DRB Application No.: 09DRB ~ 70069 Project # 1007303  
 Project Name: \_\_\_\_\_  
 Agent: Michael Eaves Phone No.: 259-5210

**CITY OF ALBUQUERQUE  
PLANNING DEPARTMENT  
March 31, 2010  
DRB Comments**

PROJECT # 1007303

RE: Tract 154-C, MRGCD Map # 32

**GENERAL NOTES:**

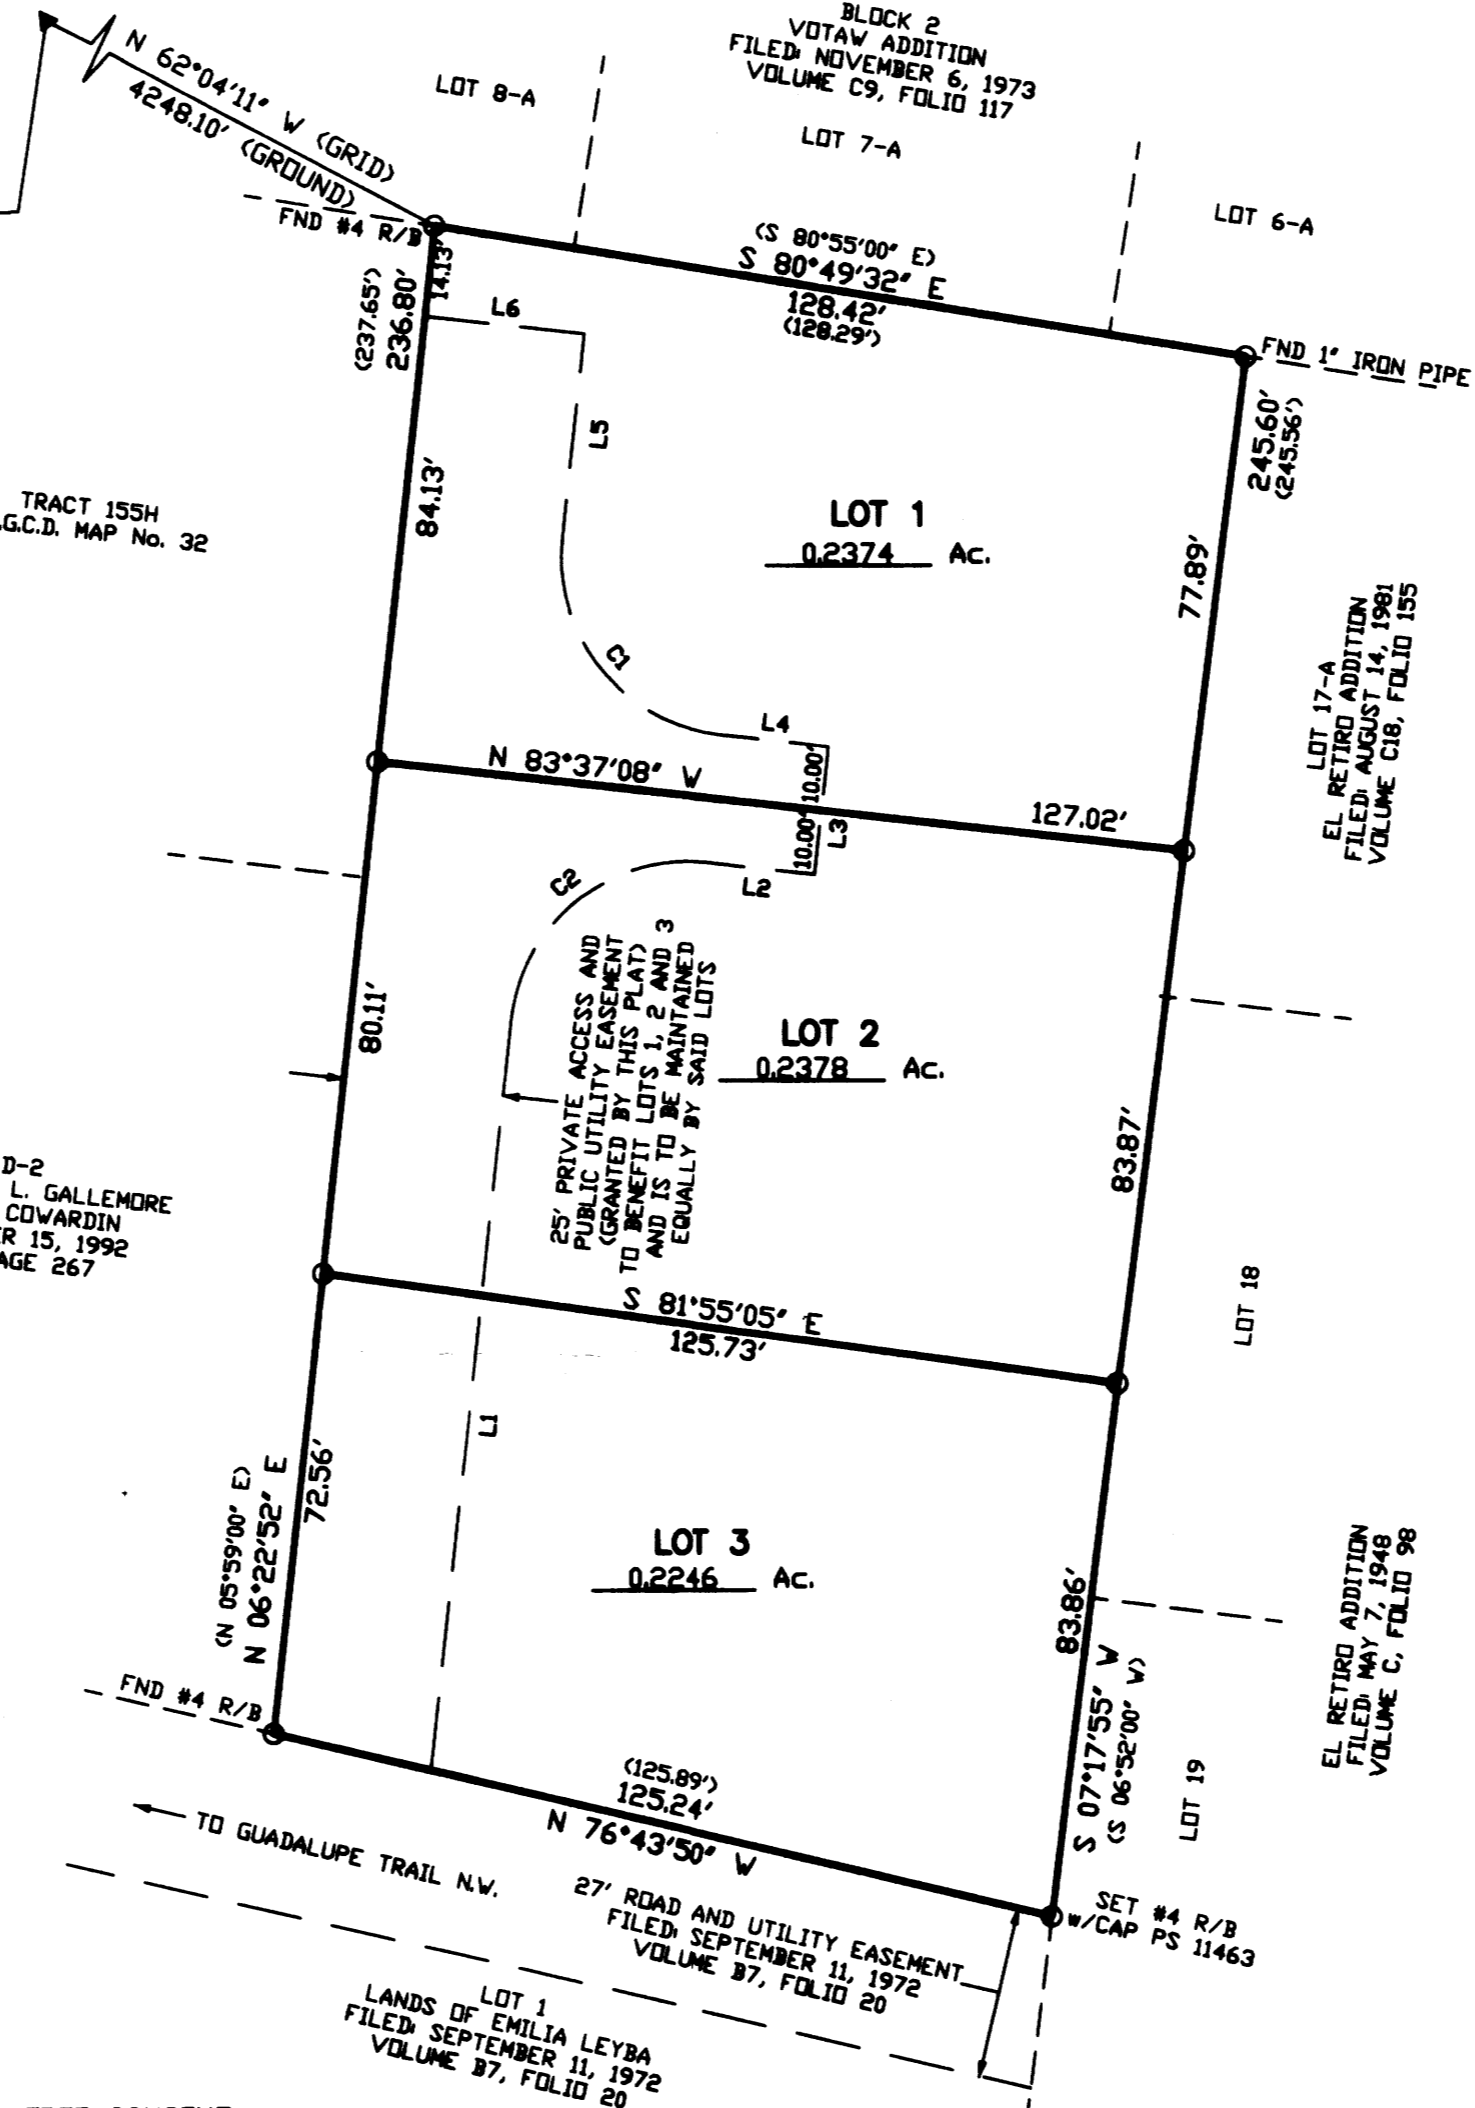
Please provide a copy of the document or plat that grants access rights/ beneficiary status to this property. It appears there are currently 12 lots using this easement, and this plat would increase by two to 14 lots.

1. There must be an Infrastructure List to include public water/sewer line extensions, service connections, and fire hydrant.
2. Plat must include private water/sewer service line easement within the driveway easement.

MICHAEL EAVES agent(s) for LA CASTILLA, LLC request(s) the above action(s) for all or a portion of Lot(s) 154C, zoned R-1, located on GUADALUPE TR NW BETWEEN MONTANO AND GRIEGOS NW containing approximately 0.705 acre(s). (F-14) **PRELIMINARY PLAT WAS APPROVED. FINAL PLAT WAS INDEFINITELY DEFERRED. CONDITION OF FINAL PLAT IS VERIFICATION OF ACCESS EASEMENT TO GUADALUPE TRAIL AND NET LOT AREA CALLED OUT ON PLAT.**

Please provide a copy of the document/ plat that grants access rights/ beneficiary status to this property. Each lot's net area (exclusive of access easement) needs to be noted on the final plat.
